Application number: 2024/90561	
What is the application for?:	Erection of side and rear extensions with associated alterations
Address of the site or building:	82, Jenkyn Lane, Shepley, Huddersfield, HD8 8AW
Postcode:	HD8 8AW

Type of comment: An objection	
Do you wish your comments to be published on the website anonymously?	Yes

PROJECT TITLE Proposed Side and rear extension @ 82 Jenkyn Lane Shepley	CLIENT Ian Spedding 82 Jenkyn Lane, Shepley
DRAWN BY Ian Spedding	DRAWING NO I.S 002
DATE February 2024	SCALE Proposed plans 1:100 @ A3

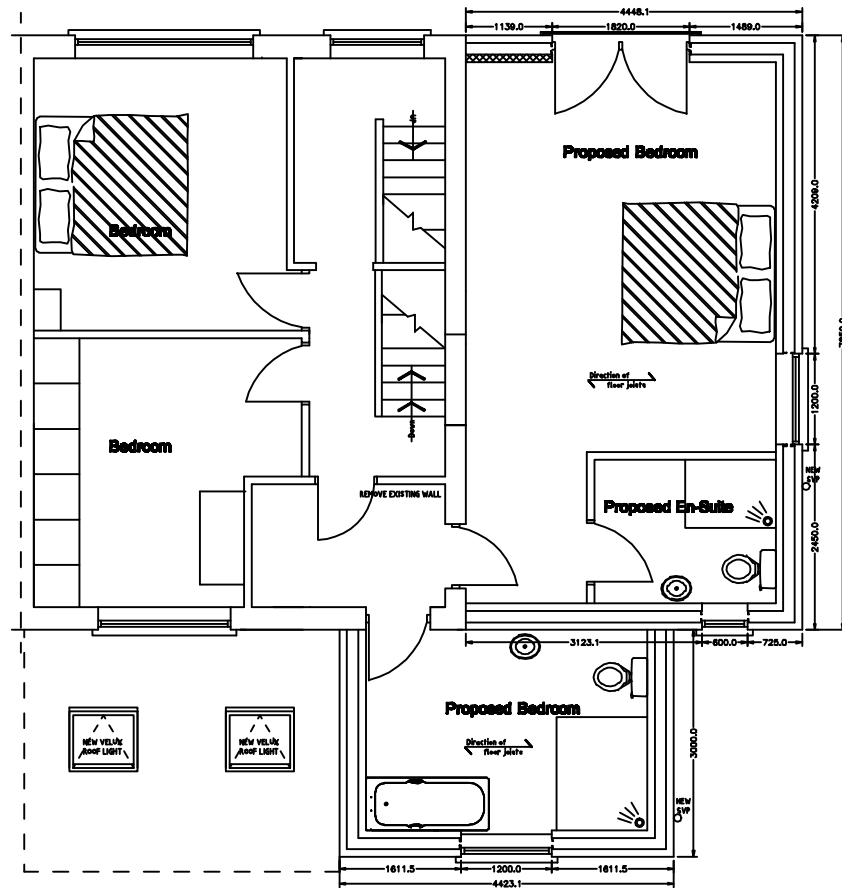
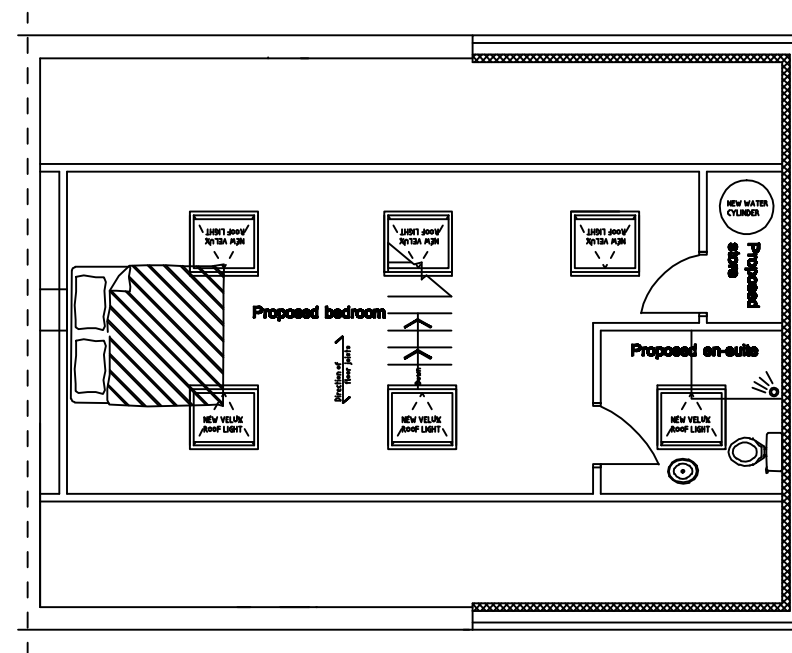
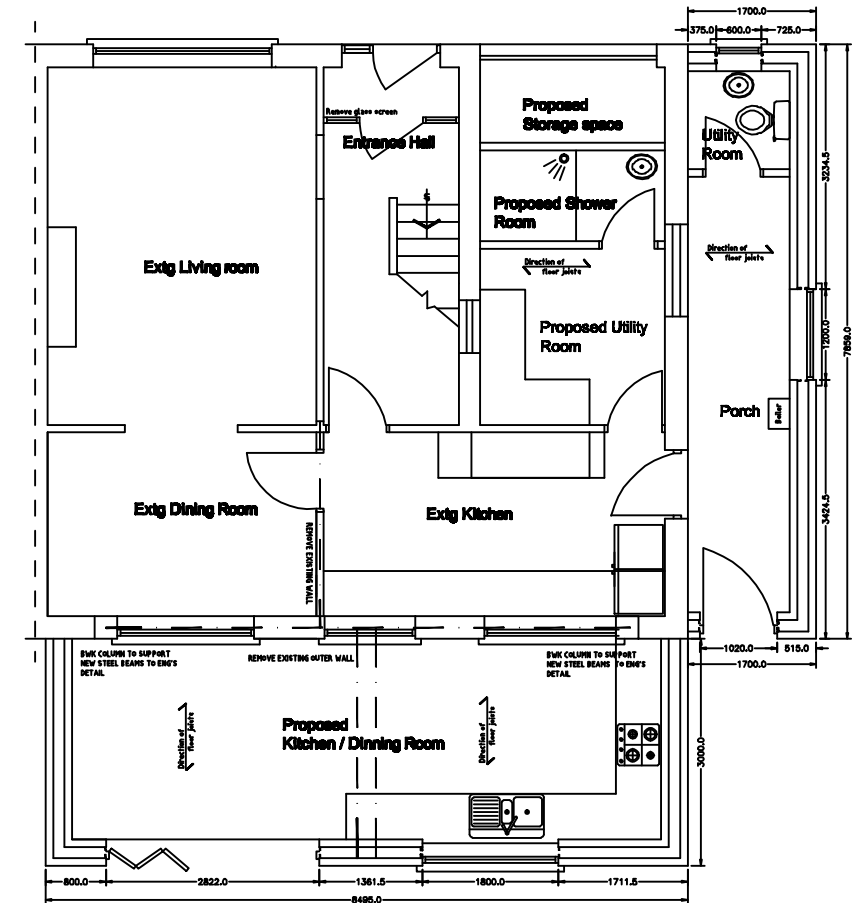
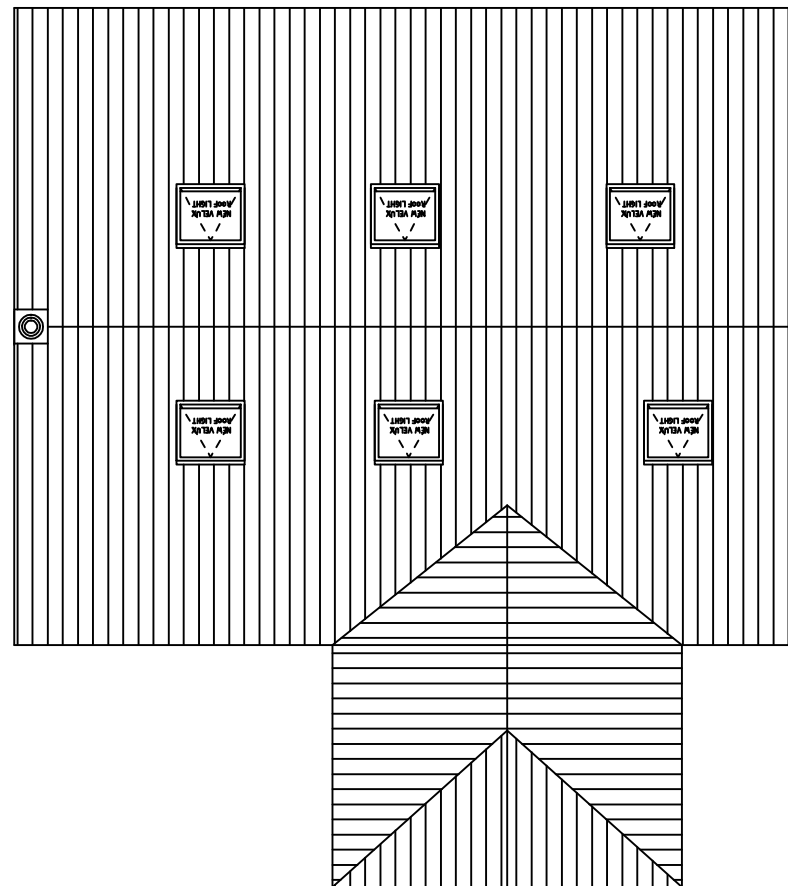
- The proposed extensions are for double storey side extension, single storey ground floor extension spanning the full width of the property (including new side) , a first floor extension moving behind the original property boundary wall and loft conversion. This is a substantial proposal and not in keeping with surrounding properties of Jenkyn Lane, Jos Lane or the wider Stocks Way development.

- The proposed extensions sizing (changing the proposed layout) could result in this property being a 5 bedroom property excluding the loft conversion which are typically used as bedrooms thus 6 bedrooms. This would be a first in the Jenkyn Lane, Jos Lane and Stocks Way developments.

PROPOSED SITE PLAN 1:500 @A4

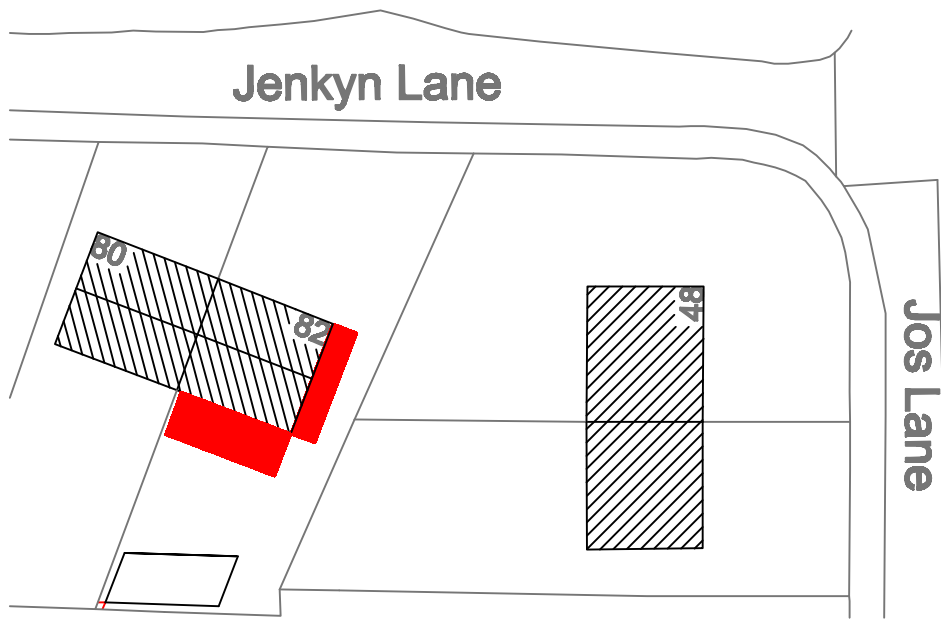
- The proposed plans will impact a considerable amount of properties that boarder the property on Jenkyn Lane, Jos Lane and Stocks Way due to the position of the property. The proposed extensions will move property boundary lines closer to neighbouring properties and gardens, removing privacy (due to amount of proposed development), light and changing the outlook of the housing development.

<p>PROJECT TITLE Proposed Side and rear extension @ 82 Jenkyn Lane Shepley</p>	<p>CLIENT Ian Spedding 82 Jenkyn Lane, Shepley</p>
<p>DRAWN BY Ian Spedding</p>	<p>DRAWING NO I.S 004</p>
<p>DATE February 2024</p>	<p>SCALE Proposed Elevations 1:100 @ A3</p>

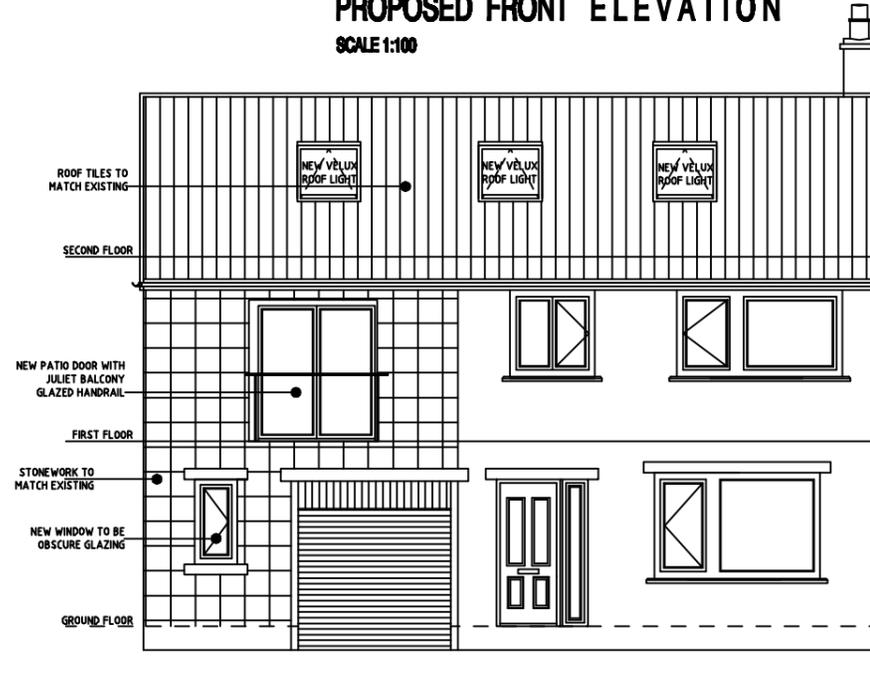
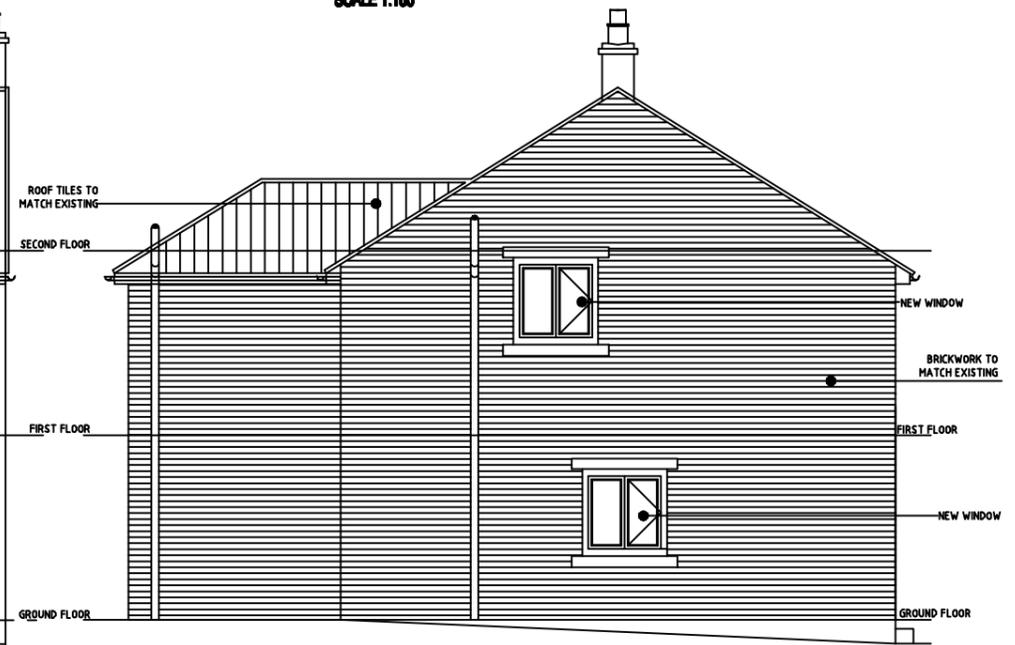
- The proposed extension front and side roof is not pitched and is not in keeping with the adjoined property or those on Jenkyn Lane, Jos Lane or Stocks Way, which has been designed to maximise loft extension space.

- The proposed frontage is not stepped back and without doing so could suggest this was the original property sizing , but with a stepped back frontage this would be out of keeping with surrounding properties whilst in a prominent property location.

- The property is positioned on the end Jenkyn Lane bordering Jos Lane. The proposed side and rear extensions will be visible from the roadside amongst the bordering properties on Jenkyn Lane, Jos Lane and Stocks Way and will be out of keeping with the surrounding properties
